Response to Applicant's video of drive-through of proposed route for construction traffic

APFP Reference
Regulation 5(2)(a)

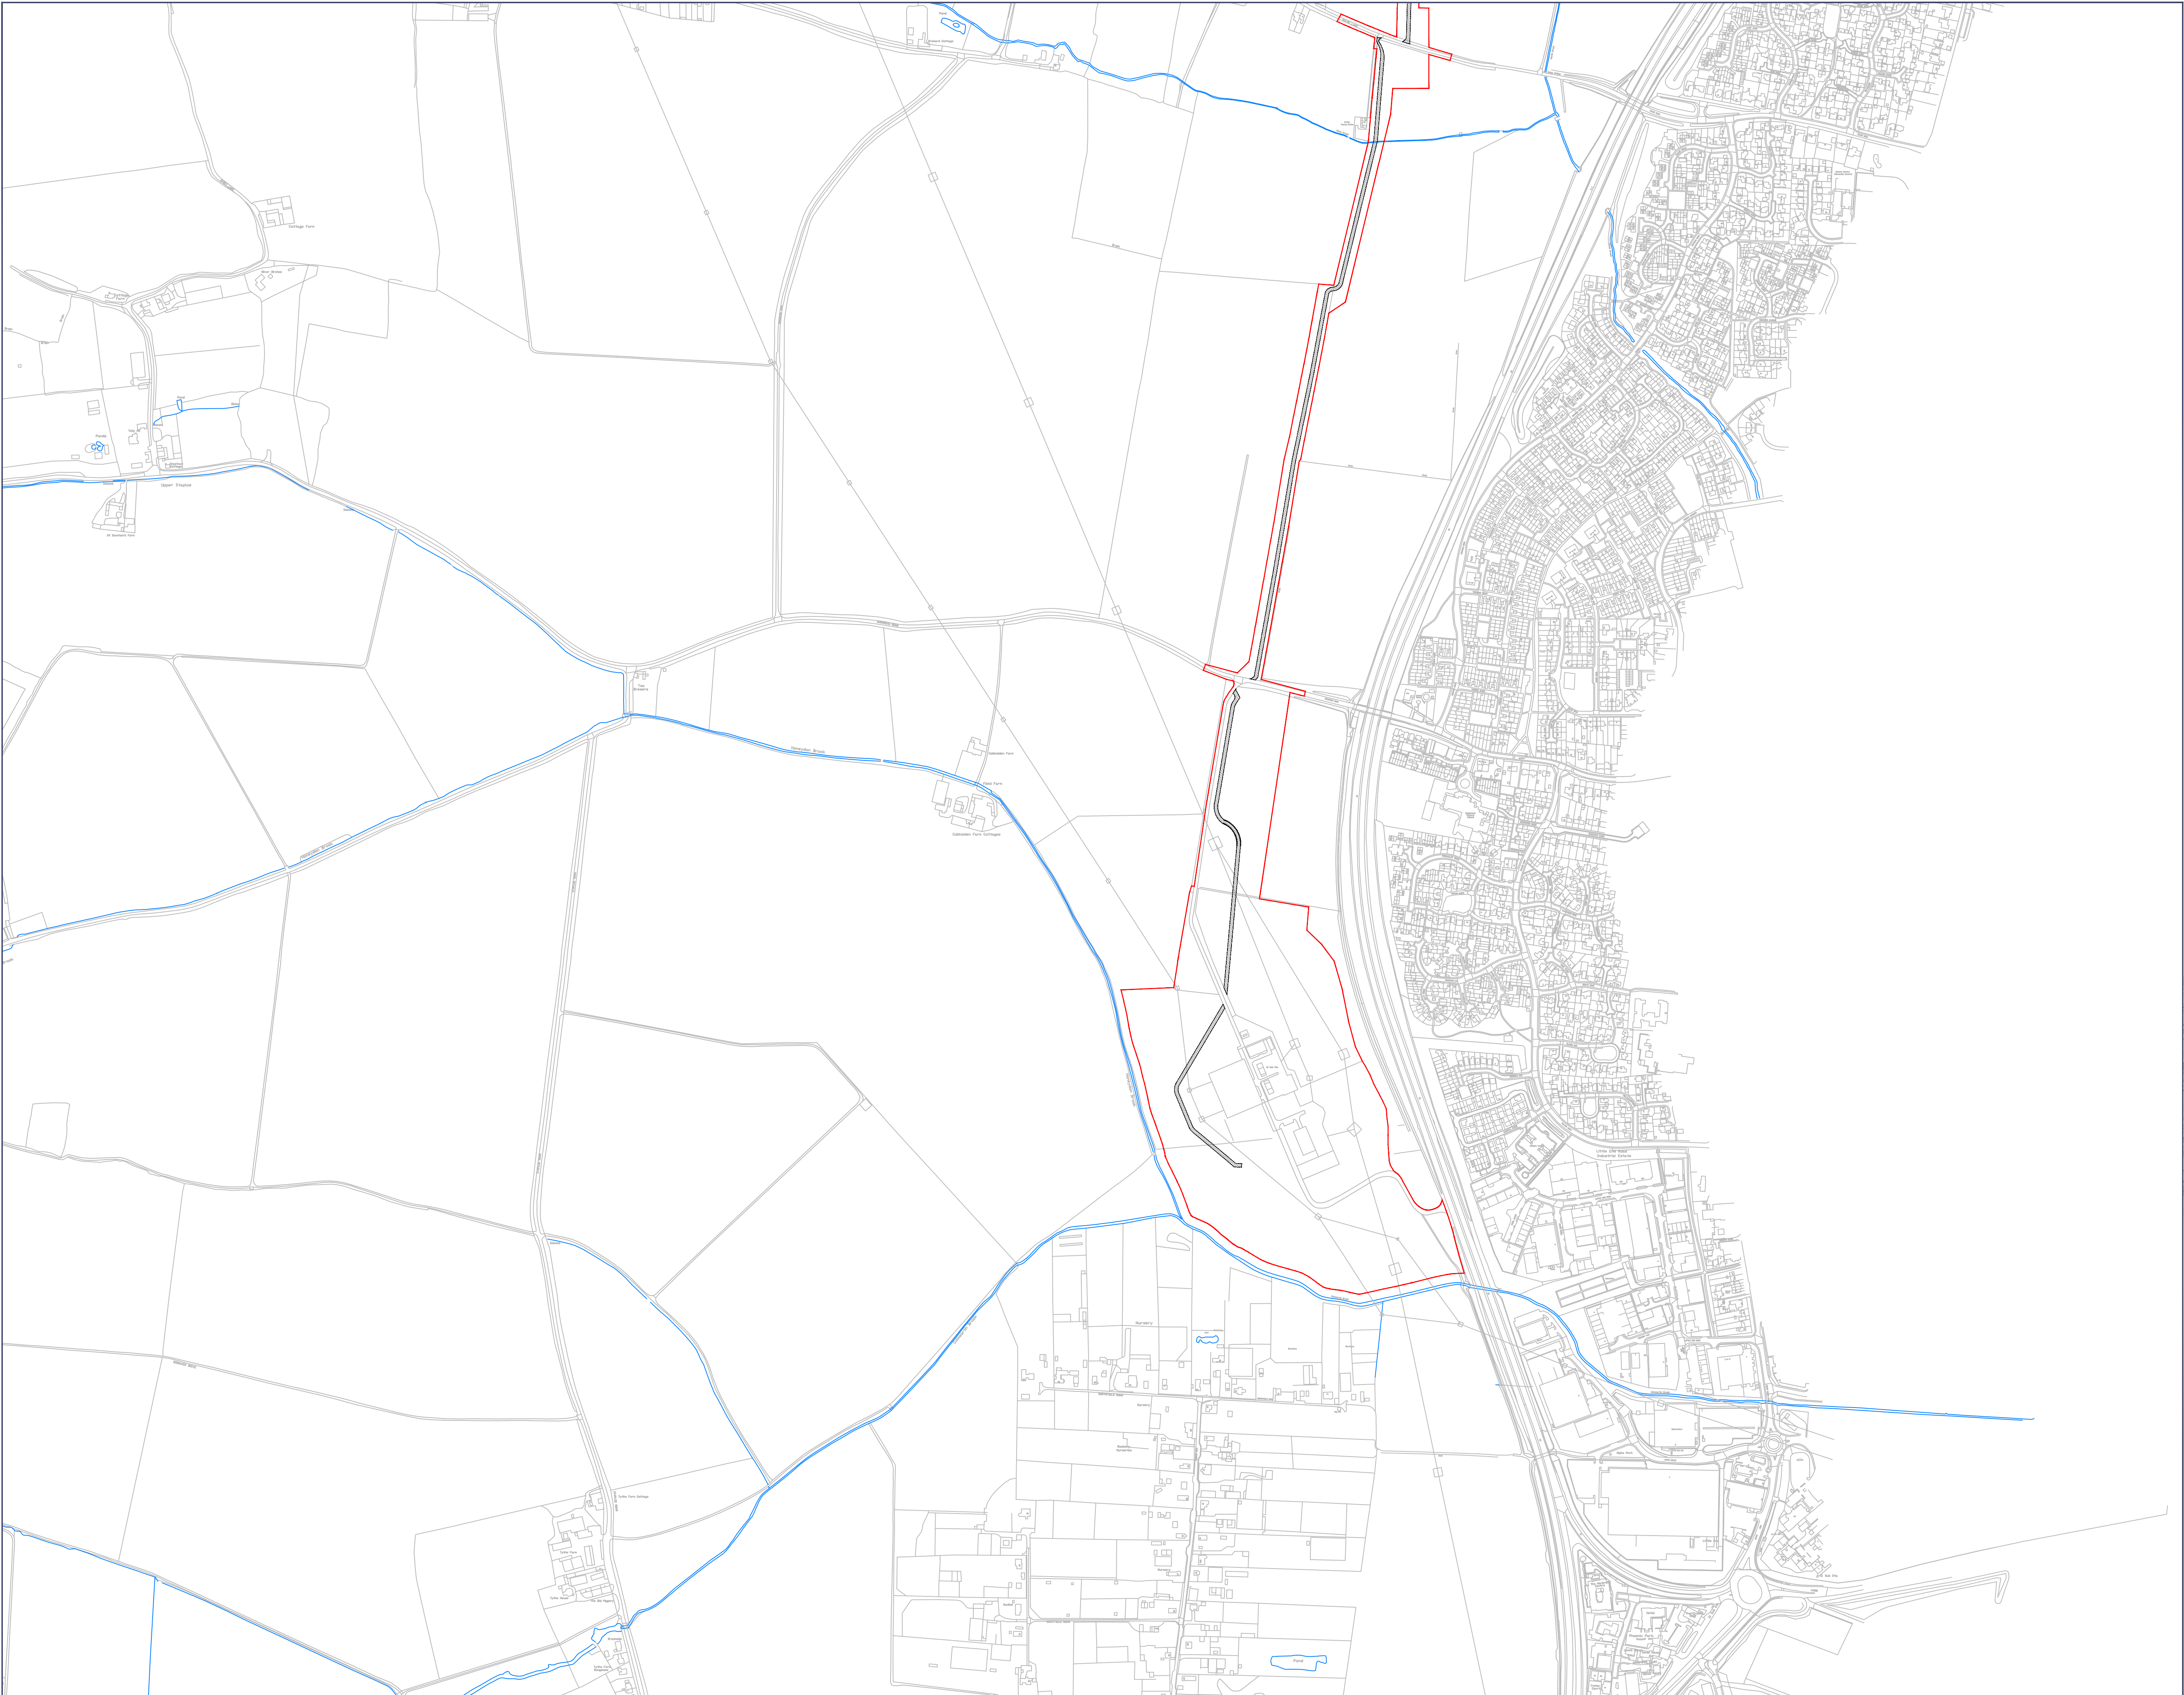
- Making the video from a HGV would have given a far more realistic view of the impact of the bends, hills and junctions that will be encountered by such vehicles during construction that may not be evident from a car.

- An indication of the time of day this video was filmed would allow a better estimation of the effects of peak traffic volumes at different times of day.

- The mileage and number of local highways being used is far greater than expected. This contradicts the Applicant's claim that constructing a temporary road network across the fields would eliminate disruption to local residents!

- Routes that will be used by HGVs during the operational stage when the temporary internal road is no longer available should also be shown as this impact will not be "insignificant".

- As HGVs and workers are only being "encouraged" to use these routes, driving routes to the different areas using only GPS guidance would show the potential impact of likely alternatives/short cuts. This would give a much more realistic portrayal of the unsuitability of the local road network which will be impacted by this scheme.
